**Land To The East Of Stratfield Brake And West Of Oxford Parkway Railway Station
Oxford Road Kidlington**

Reference Number: 24/00539/F

This is supplementary to my letter of the 15th April.

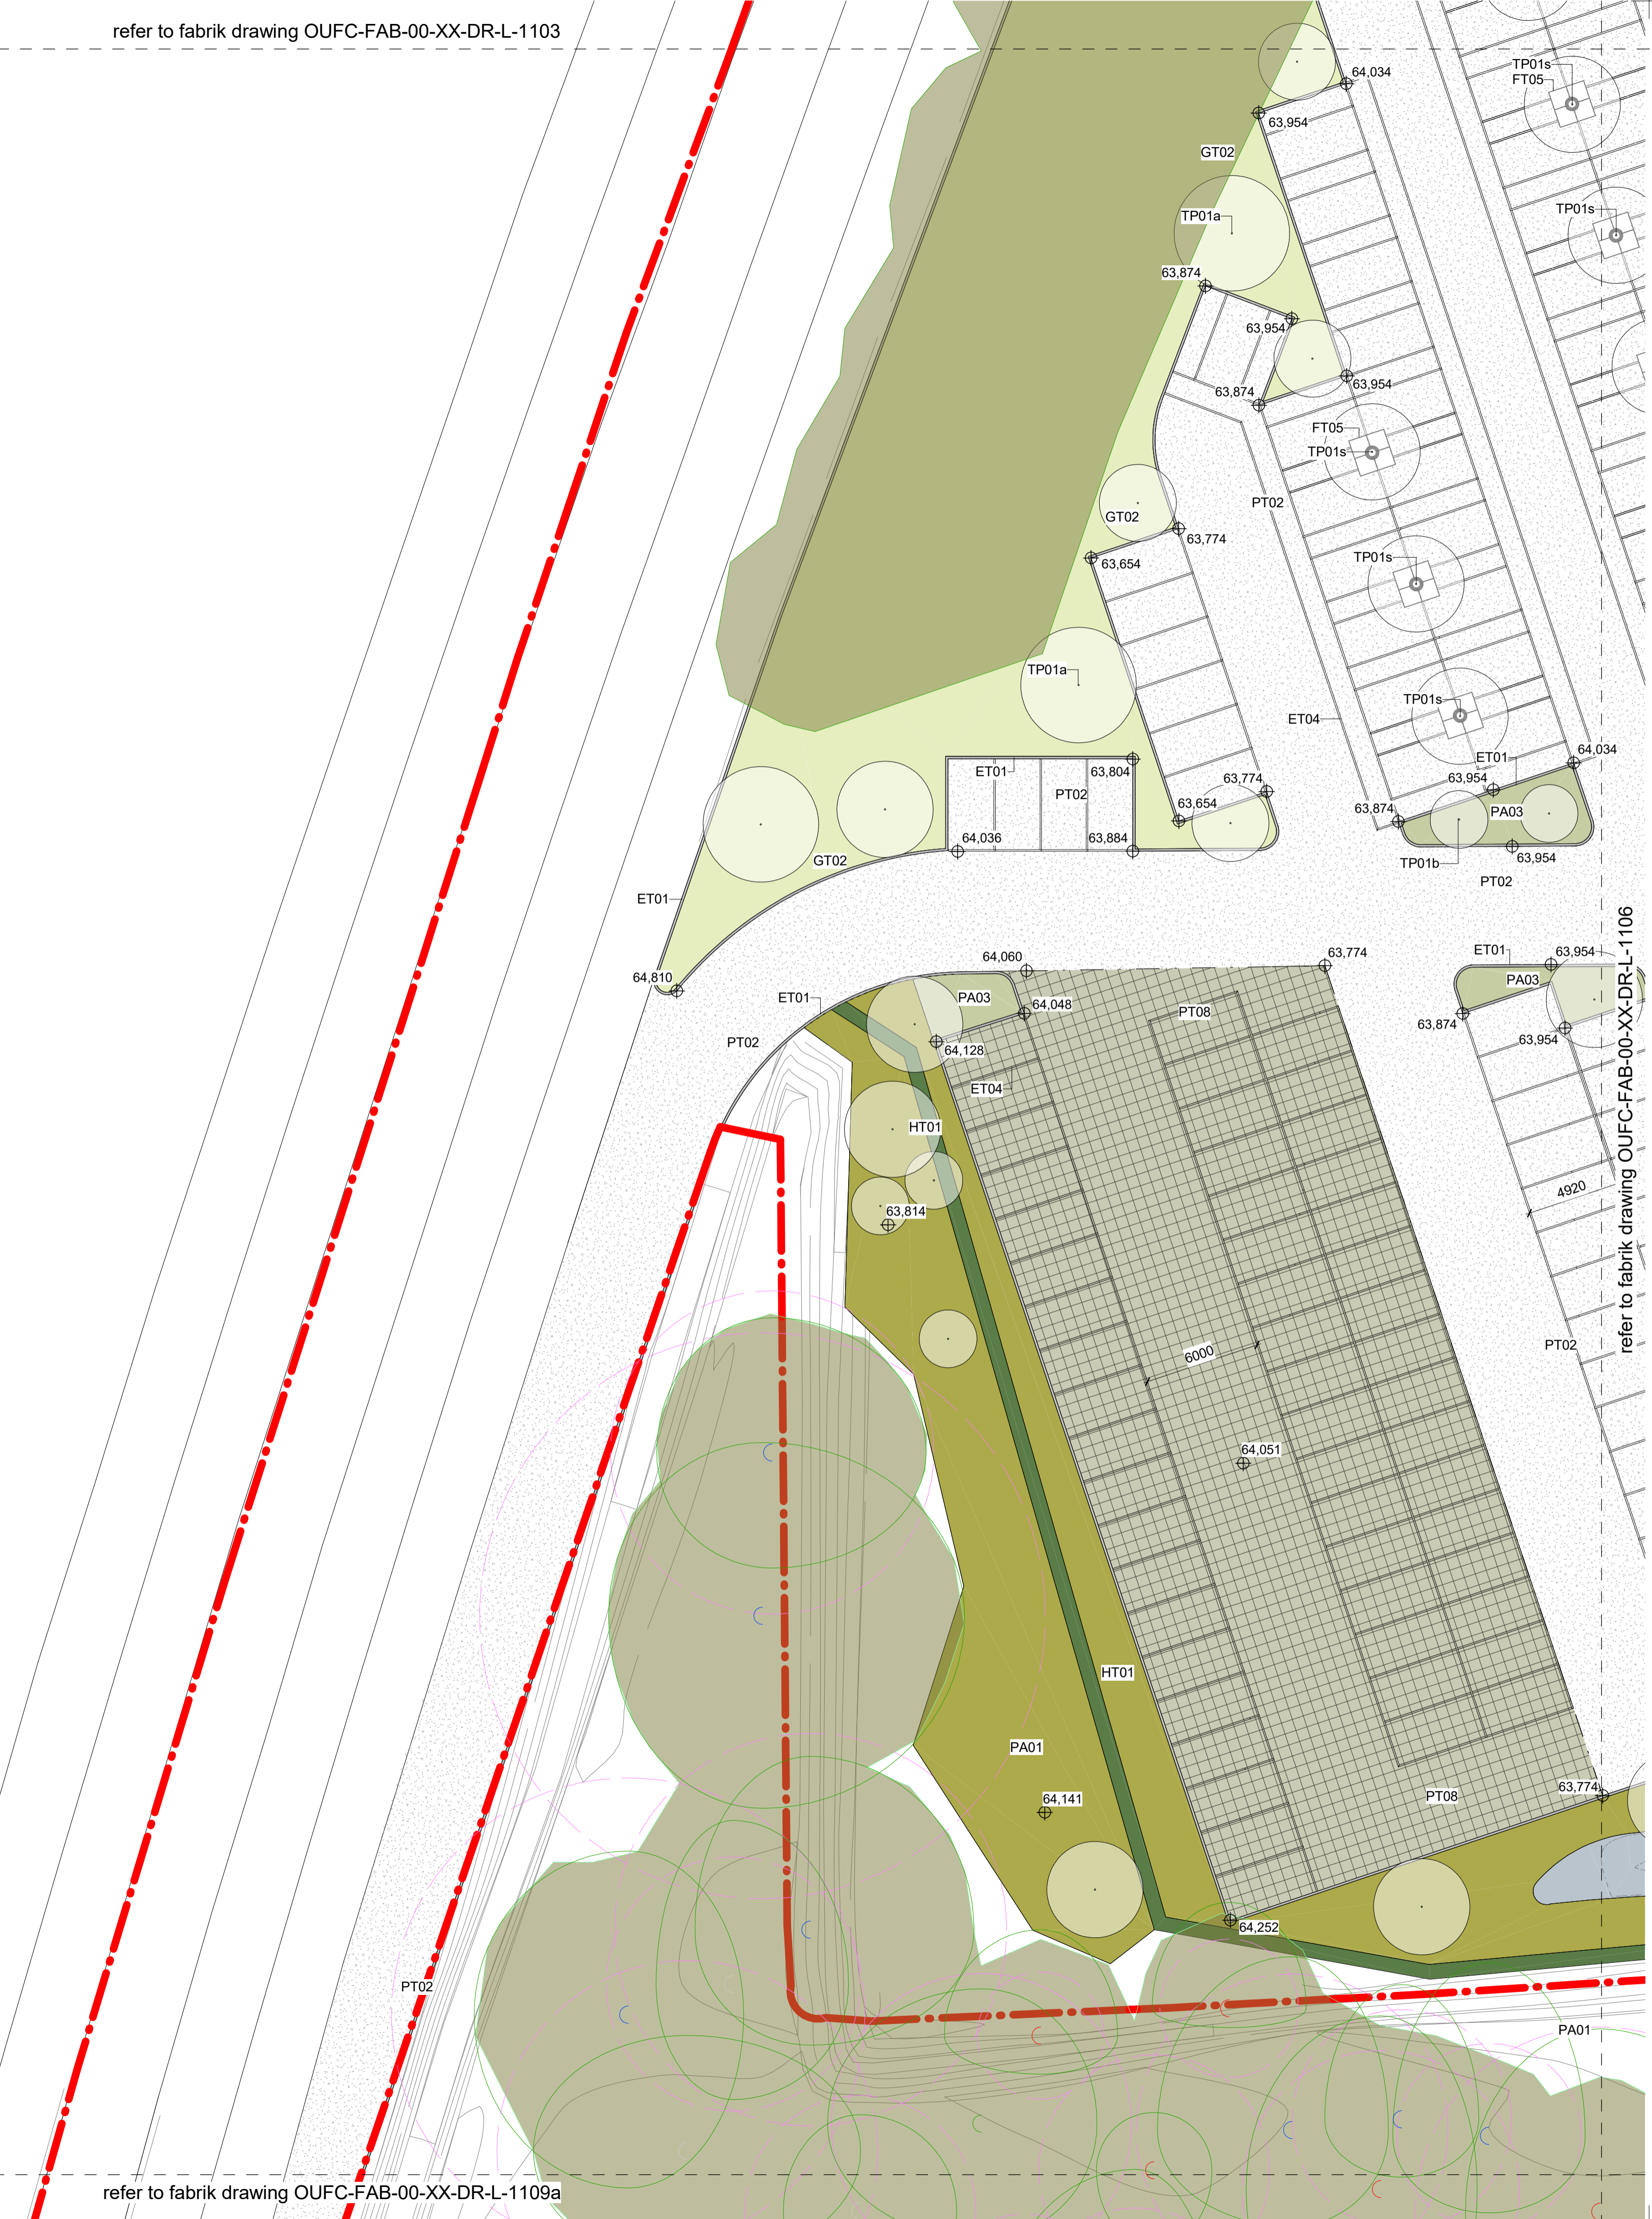
The line of these existing power cables is not shown in "ES Volume 2 4.7 Landscape site with wide GA plan.pdf", however "SS with associated parking" ("SS I take to mean Sub Station) is shown close to the eastern boundary, and it is under the approximate line of a high voltage cable so there is consistency there. The cables are shown on the "Appendix H Site walkover technical note.pdf" but greyed out and not referenced – surely quite a significant omission) nor are the associated pylons – there are 4 on the site that I have identified on Google Earth. Is this significant? Whilst the lines do not actually impinge on the Stadium Building, they could be in the way of construction or maintenance plant, will they need to be re-routed?

On "ES Volume 2 4.7 Landscape site with wide GA plan.pdf" there are a number of trees proposed ("14 - Proposed Tree Planting (below extra heavy standard size, 62 in total") - this planting may not be feasible under or in close proximity to the power lines.

There are other trees shown that are not apparent on Google Earth or the September 2023 Streetview image, on the roadside verge small triangle outside the Stratfield Brake Sports Ground turn off the Frieze Way, that may be prejudiced by their proximity to these pylons and cables (15 on the Legend, "Proposed Trees, 30cm girth and above, 81 in total).
